PCD PM-Site Development Plan Comments.pdf Markup Summary

[1] SDA-1 (6)

SDA-1

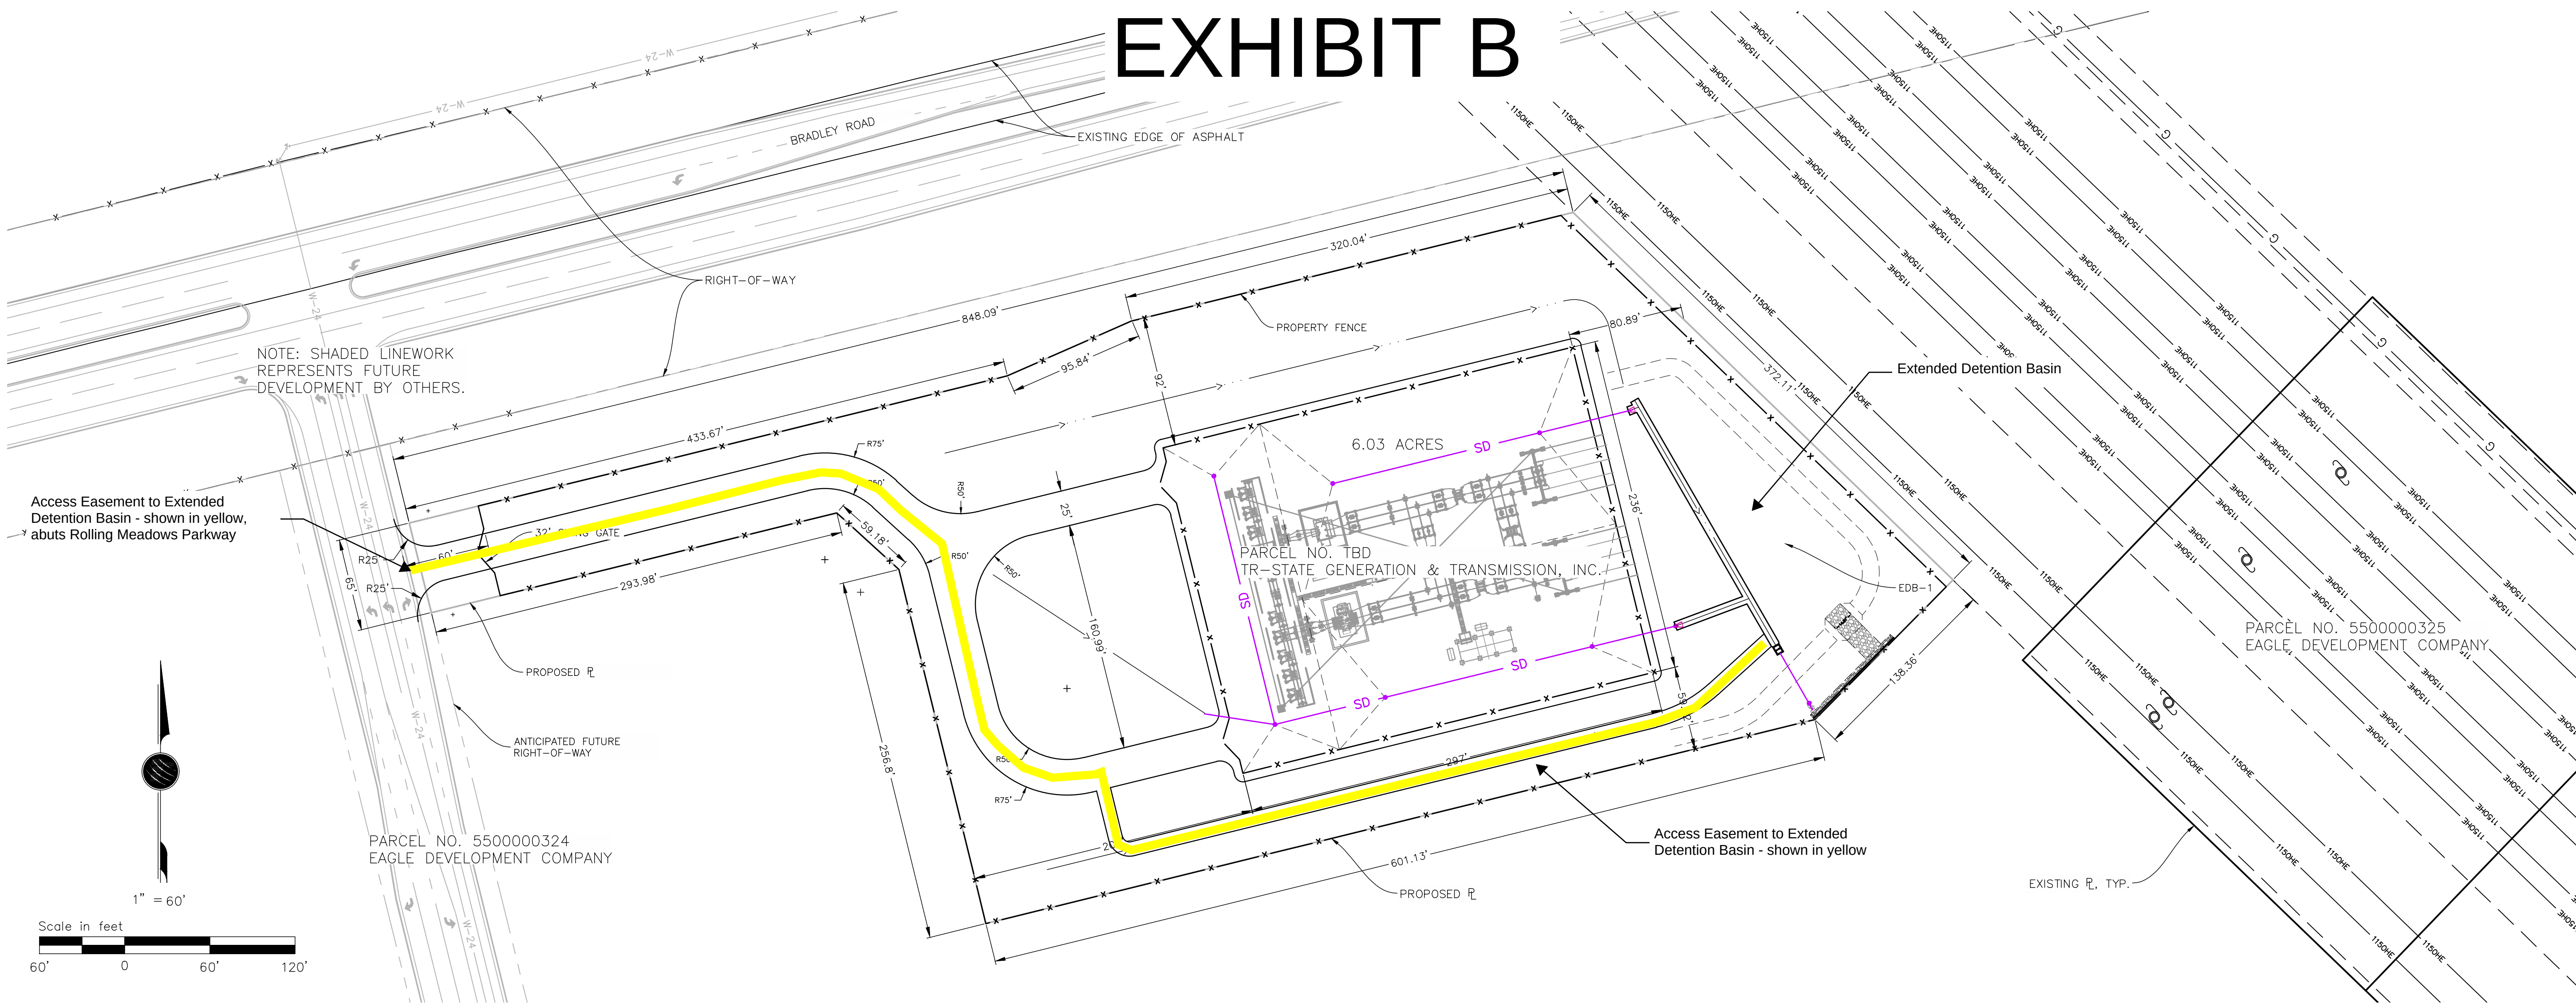
Does this facility plan to be in operation prior to the future development being completed? If so, then show/discuss how access is achieved prior to future road construction,

Please delete detail shown and use EPC Std Details SD_2-23 (Driveway cut) & SD_2-25 (Driveway w/detached sidewalk). Future road driveway is connecting to is not a rural local road, it is an urban collector.

Please delete detail shown and use EPC Std Details SD_2-23 (Driveway cut) & SD_2-25 (Driveway w/detached sidewalk). Future road driveway is connecting to is not a rural local road, it is an urban collector.

Landscaping plan required per PUD

Missing:
- Legend
- property lines depicted and labeled
- setbacks
- landscaping plan
- lighting detail

Use existing parcel #

Please label uses and areas on this Site Dev Plan

DMC RESPONSE: Drive has been extended to Bradley Rd.

DMC RESPONSE: Because there will now be an entrance off of Bradley Rd, we are keeping the existing rural local road detail.

DMC RESPONSE: Landscaping plan no longer required per discussions with EPC, see revised Letter of Intent

DMC RESPONSE:
Legend added
Property lines depicted and labeled
No setback required for this property
Landscaping and Lighting plans not required

DMC RESPONSE: Parcel number updated to existing

DMC RESPONSE: Use and area labels added
